Recommendation Report for Planning Permission for Works or Extension to a Dwelling

REF NO: R/205/21/HH

LOCATION: 8 Frobisher Way
Rustington
BN16 2BA

PROPOSAL: Single storey porch extension and alterations to the external fenestration.

DRAWING TITLE:
ROOF PLANS Ex / Proposed

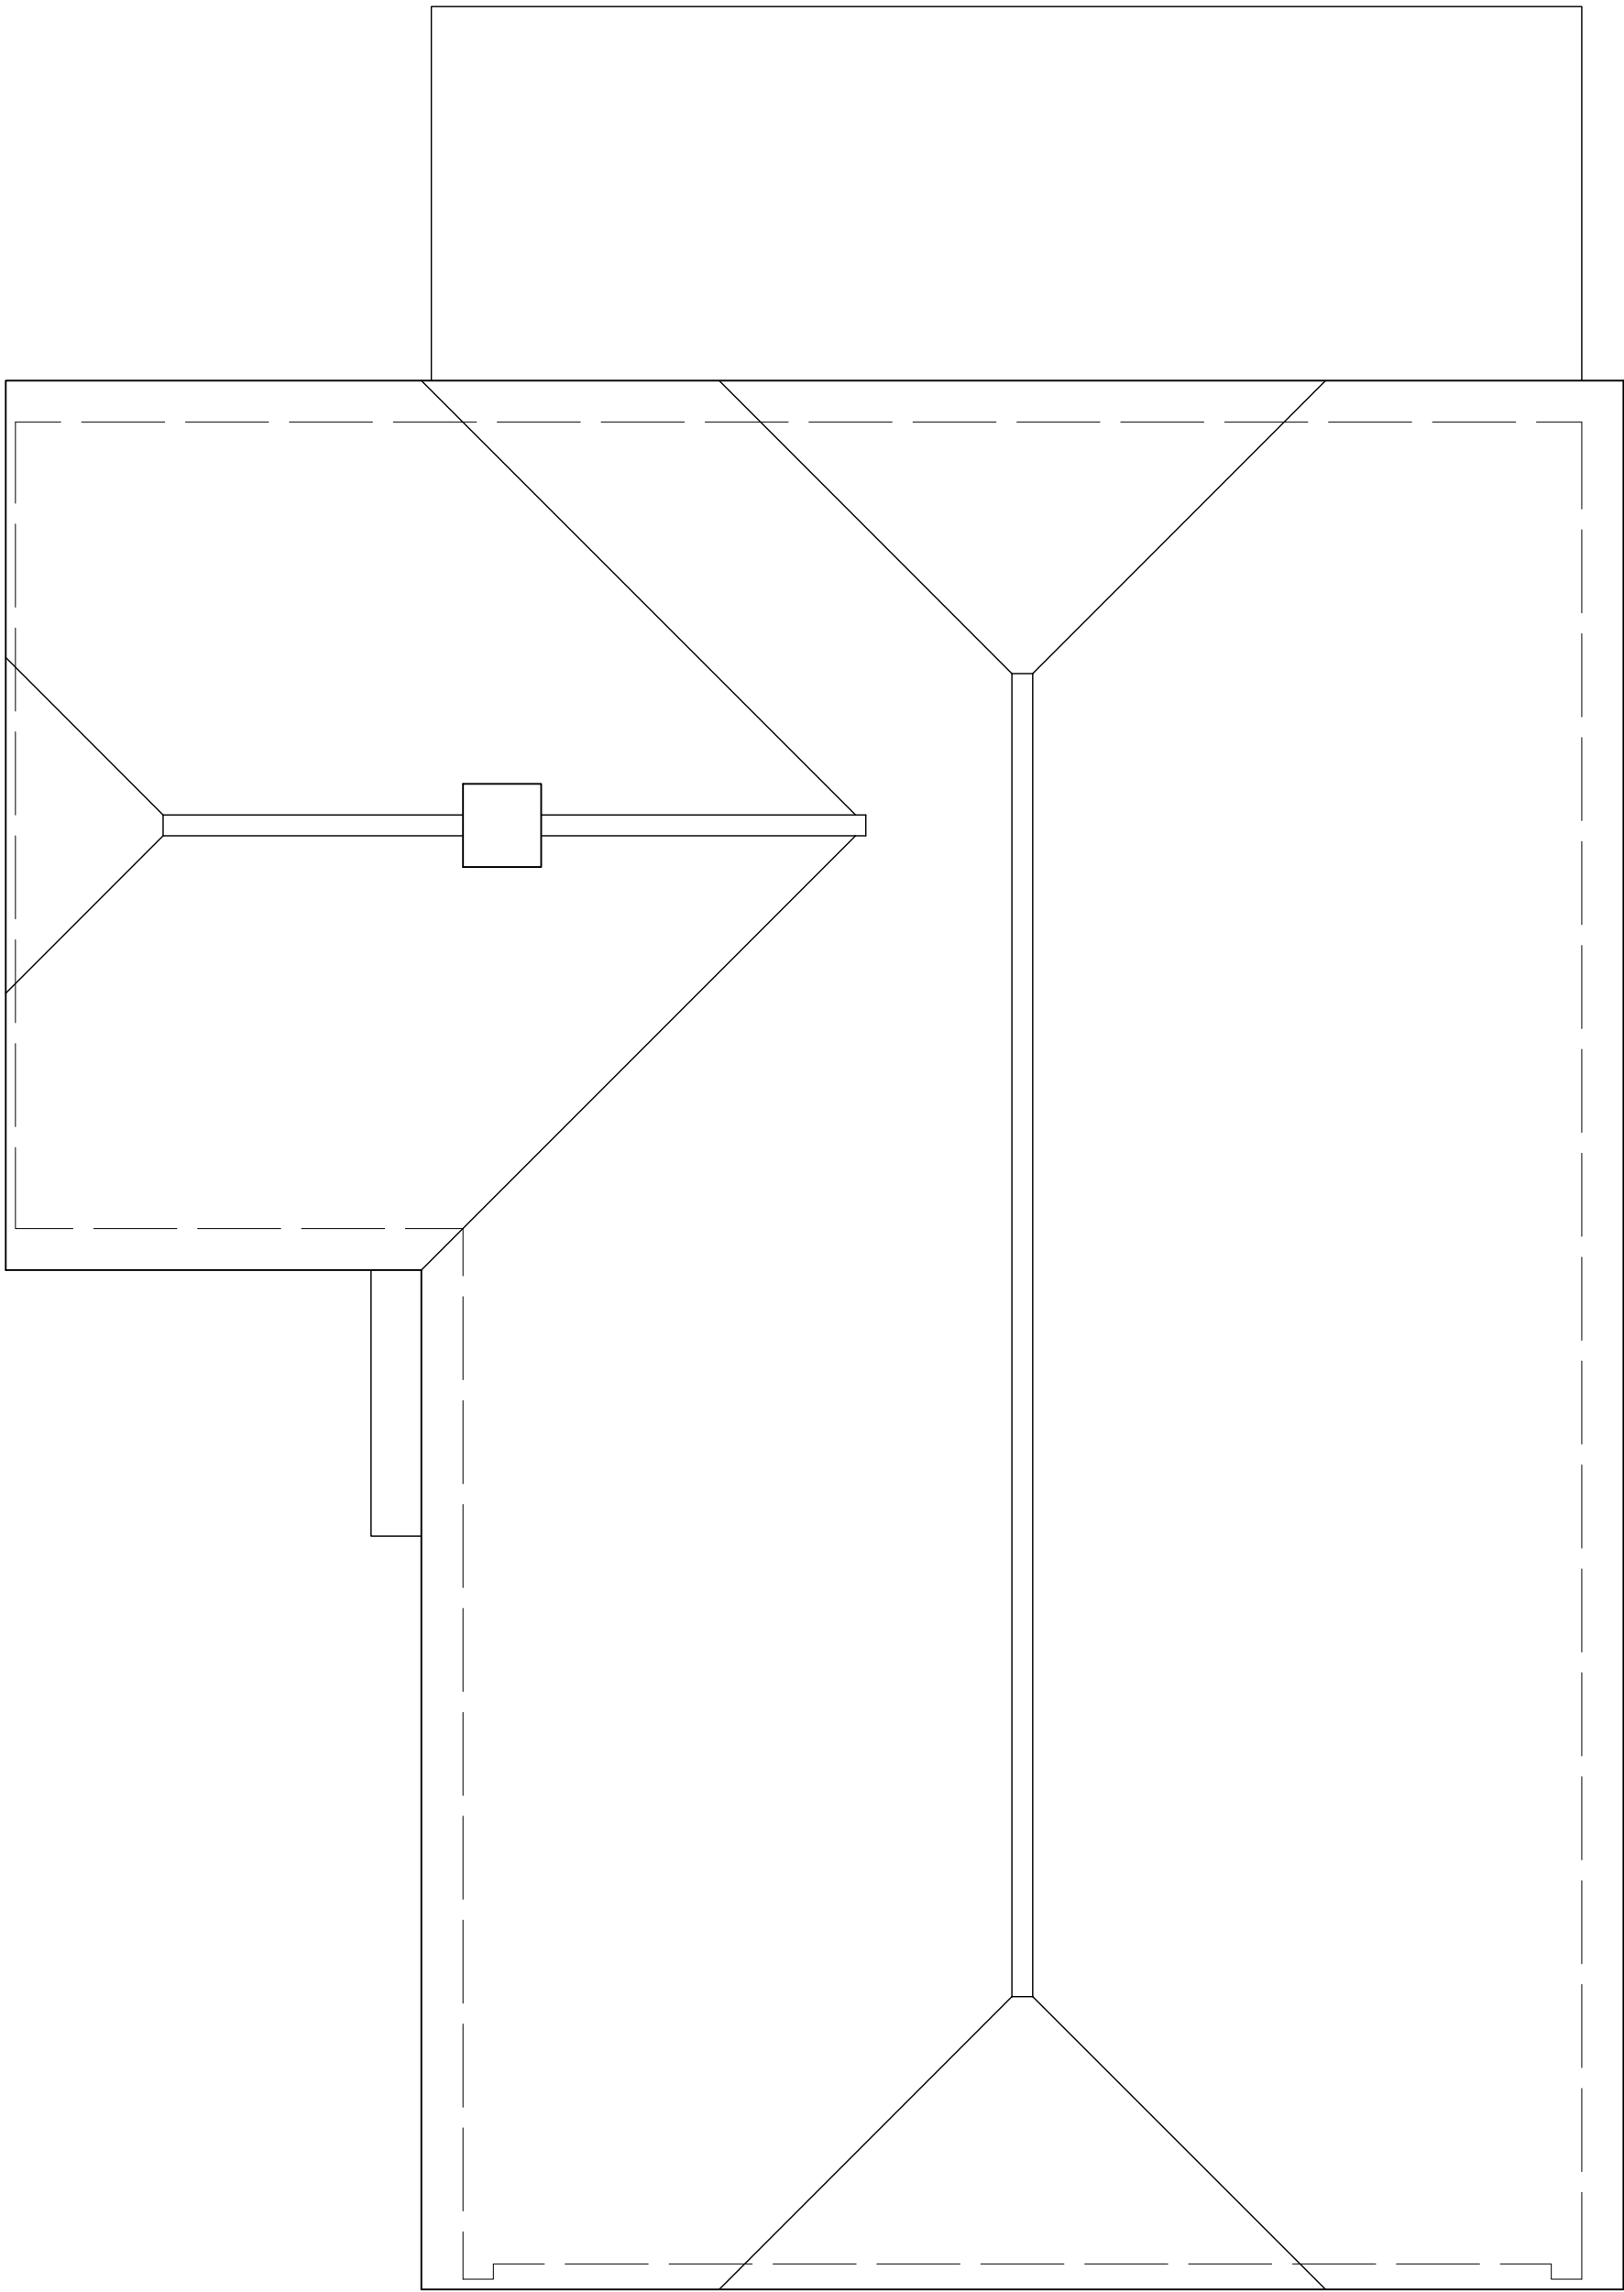
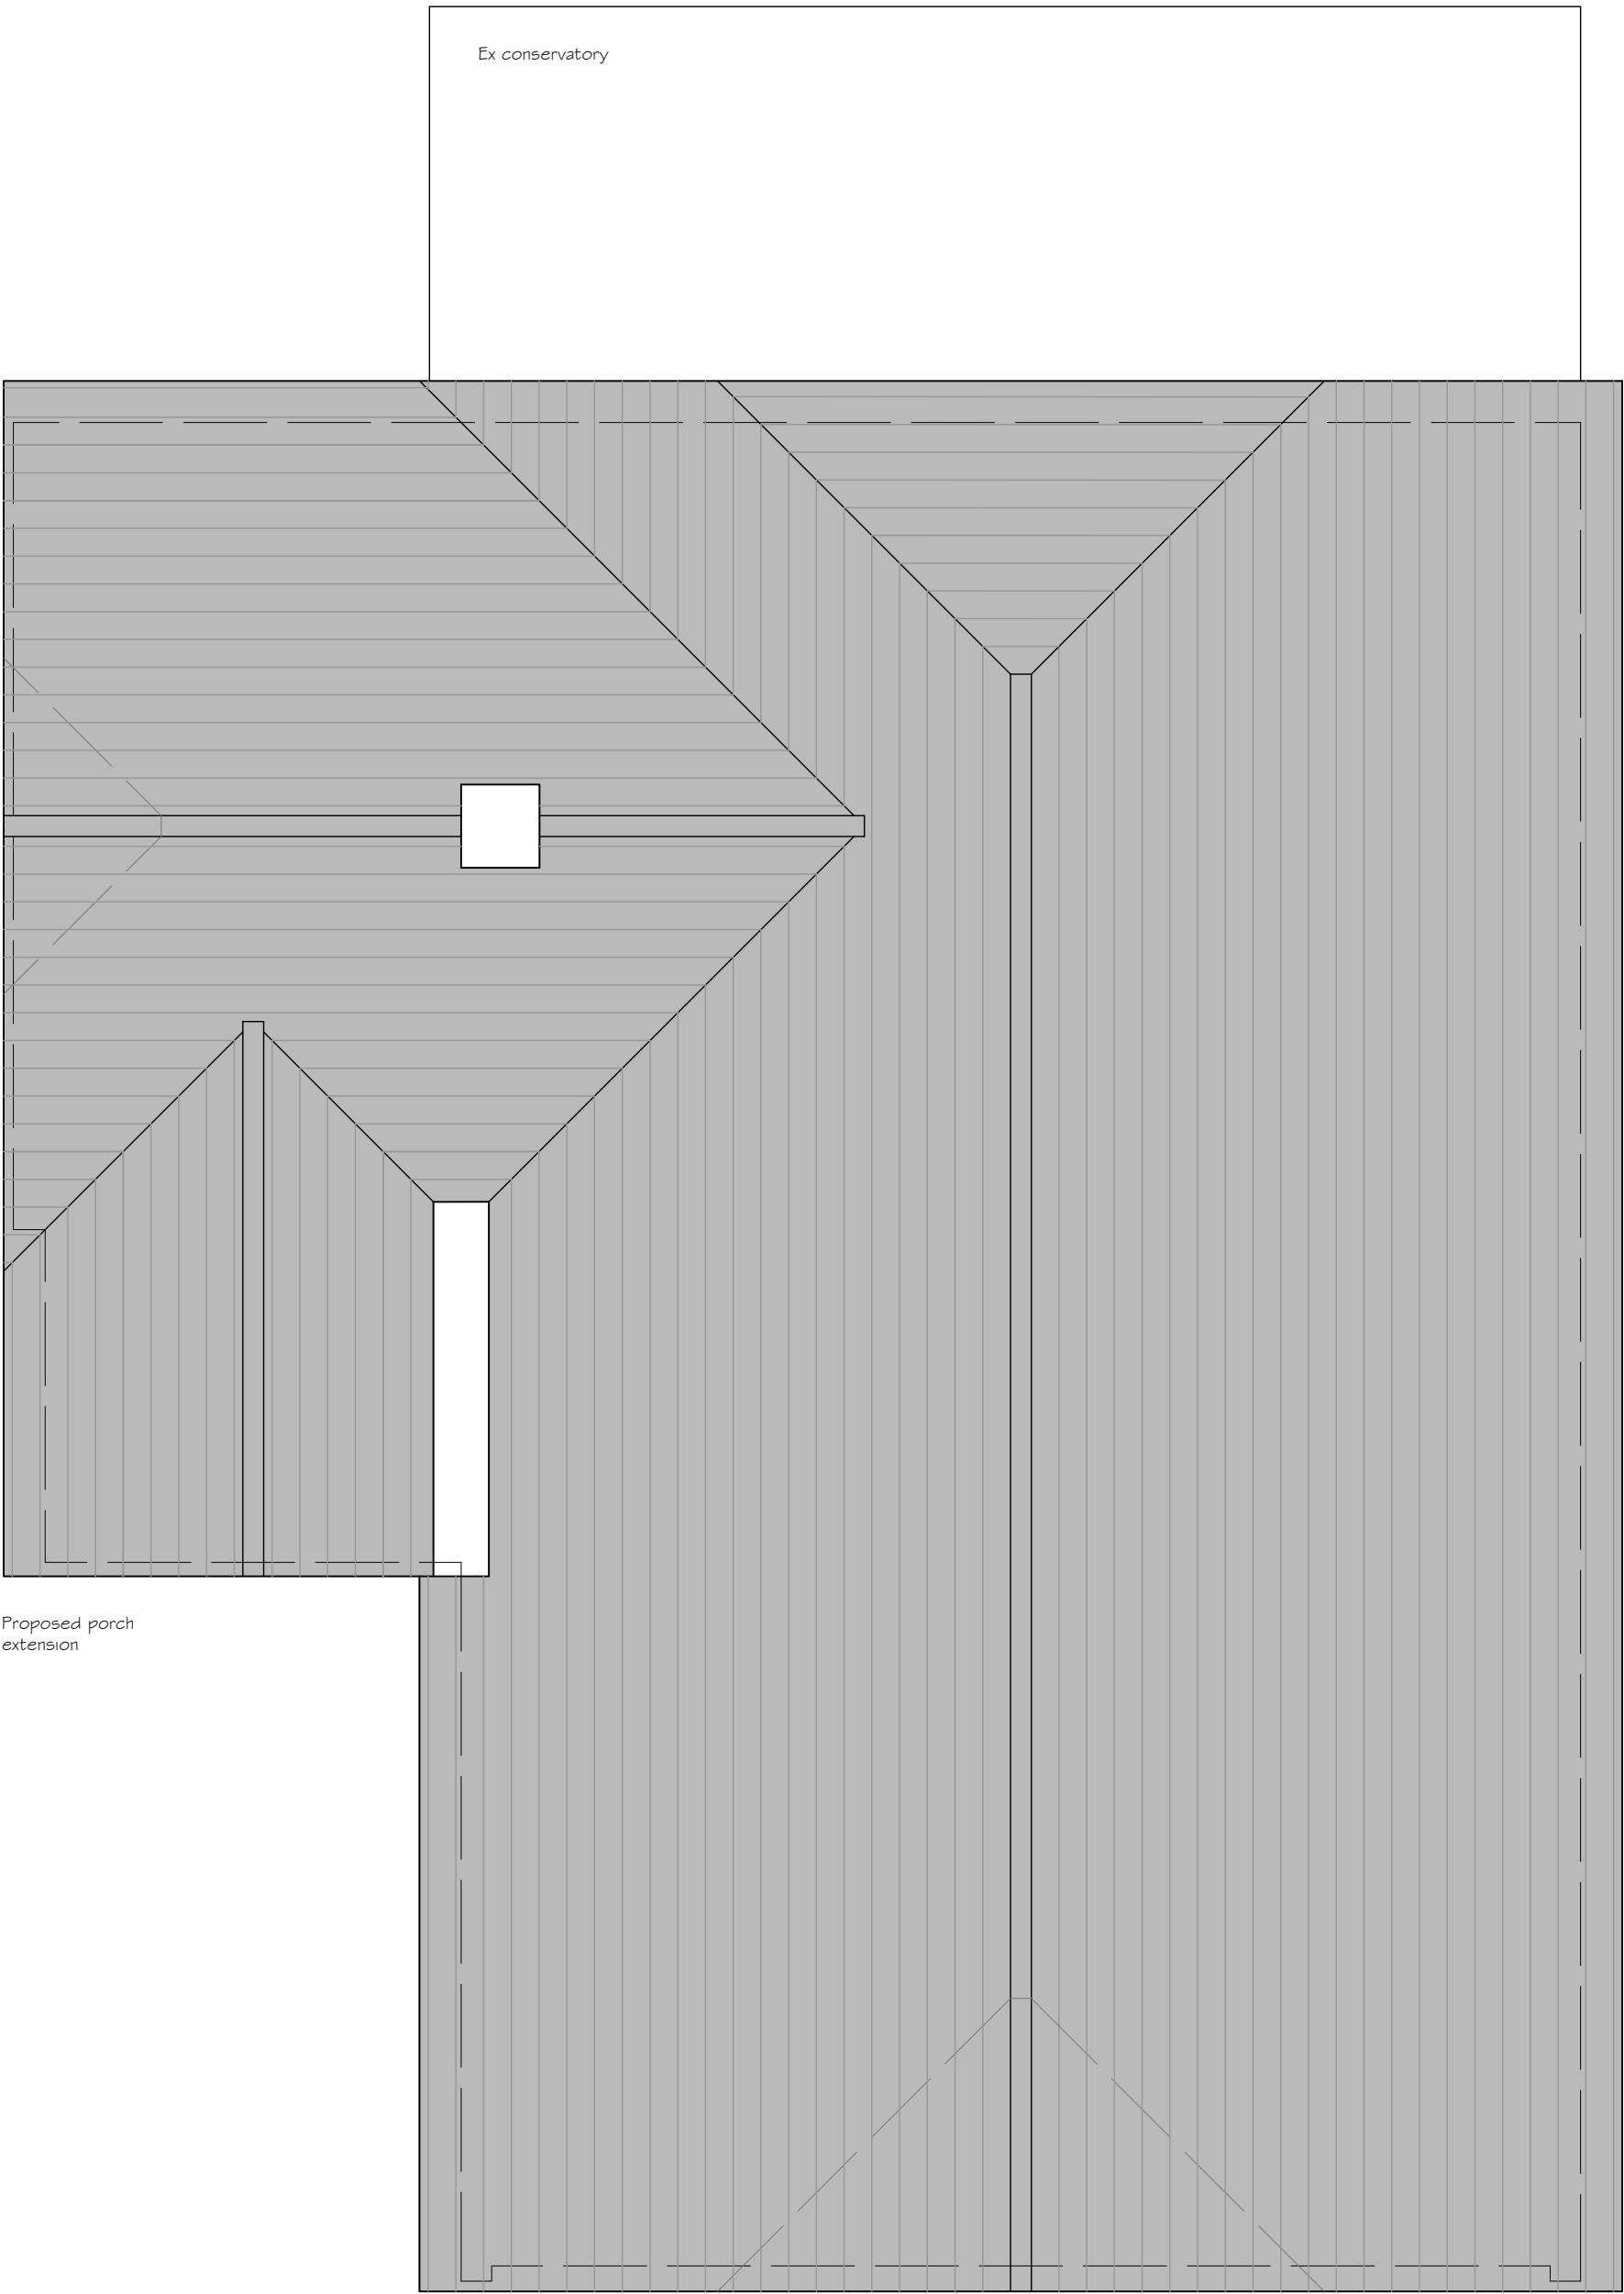
The proposed alterations to existing roof will consist of existing barn ends to side (south) and front (east) roof planes removed and brick gables extended. Due to alterations being at side and front they are visible from the street scene however do not cause adverse harm to street scene due to surrounding properties having a mixture of different types of roof designs such as Gable Ends or pitched roofs so the proposals are not out of character with surrounding area so will comply.

There will be new materials for roof with existing plain roof tiles to be replaced with large grey tiles / slates colour TBC.

The alterations to the roof from existing barn ends to side (south) and front (east) roof planes removed and brick gables extended will not cause increased impact of overshadowing or overbearing effects to neighbouring properties so is considered acceptable.
